Description: Erection of a 4 bed detached
house and detached double
garage

Location: Adjacent Cromwell House
Holbeach Bank
Spalding
Lincs

Amendment: Link added between house and garage and general alterations
Dwg. Nos. SD01-025/1C and MAY-01D

**RE: 4 BEDROOM DETACHED HOUSE ADJACENT CROMWELL HOUSE HOLBEACH
CLOUGH FOR FENBANK BUILDERS**

1:200 1:2500 SD01-025/1

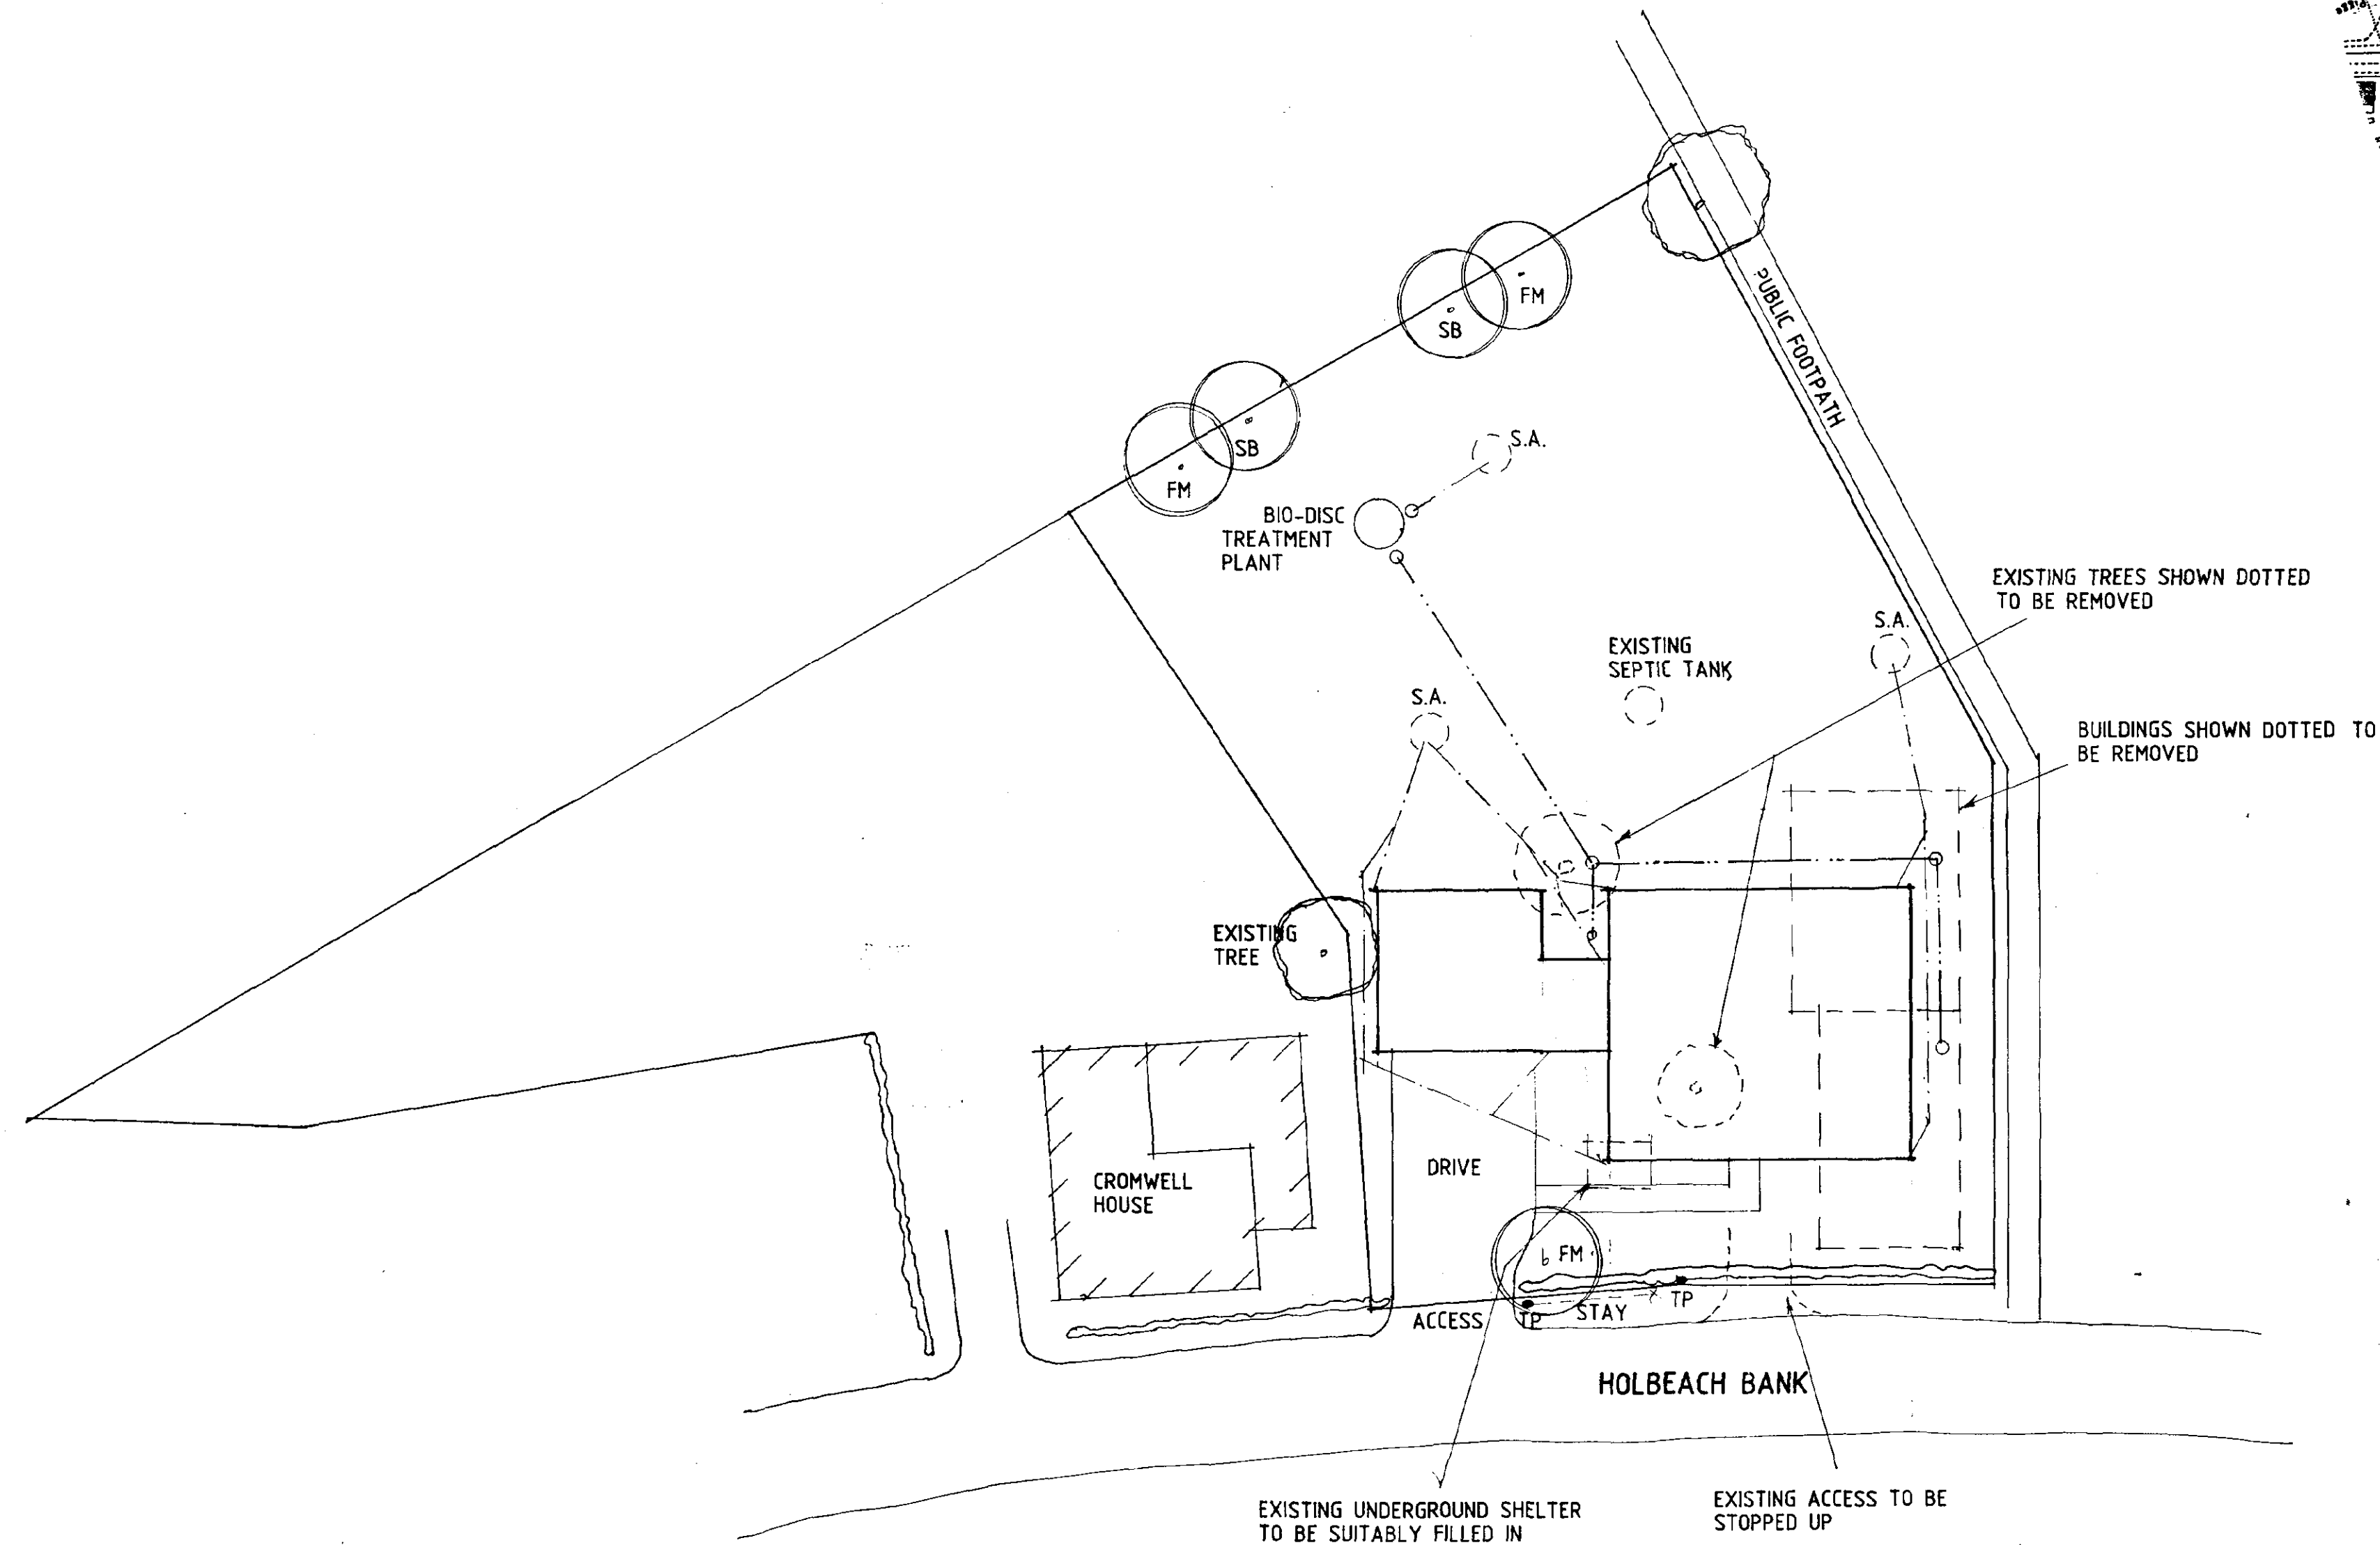
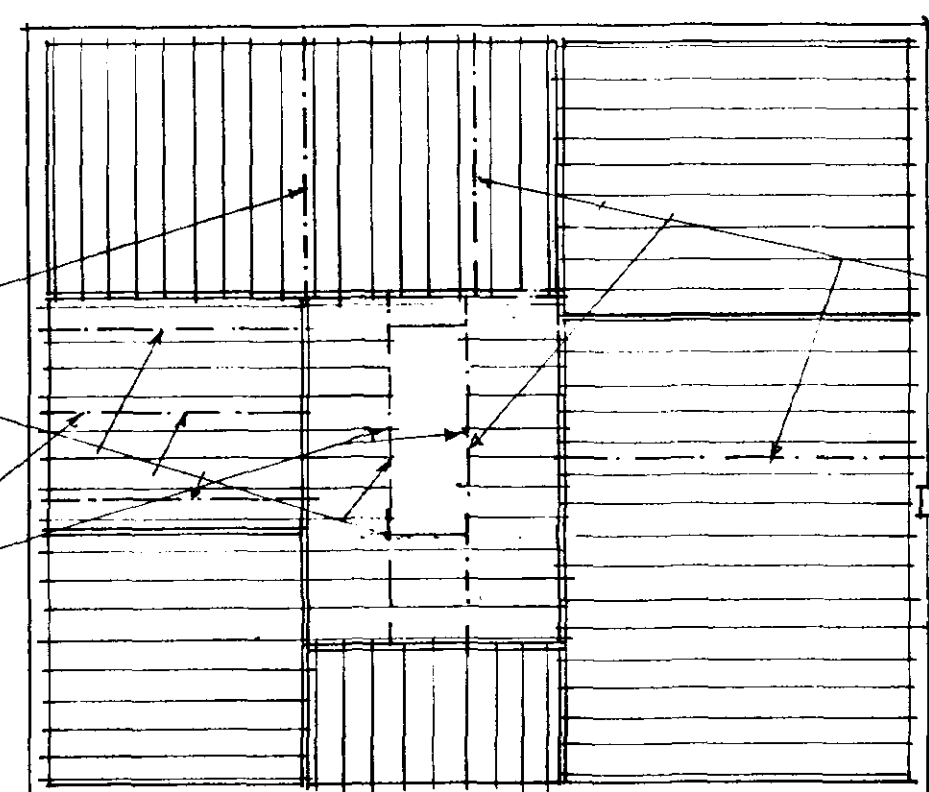
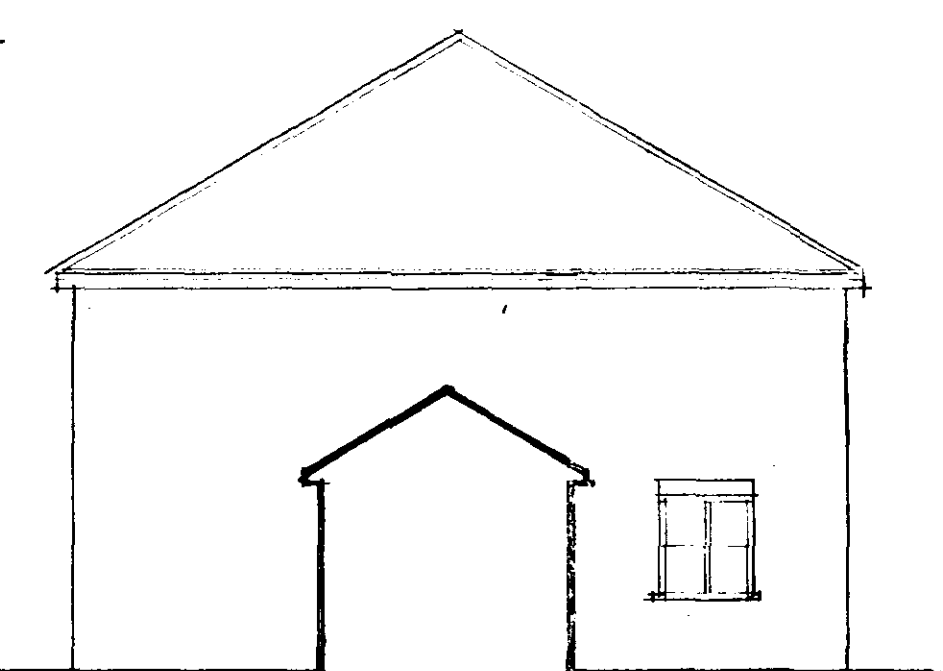
LINK ADDED BETWEEN HOUSE
& DOUBLE GARAGE & GENERAL
ALTERATIONS

There have been general alterations to the above proposal including a link between the house and double garage. I therefore enclose the following:
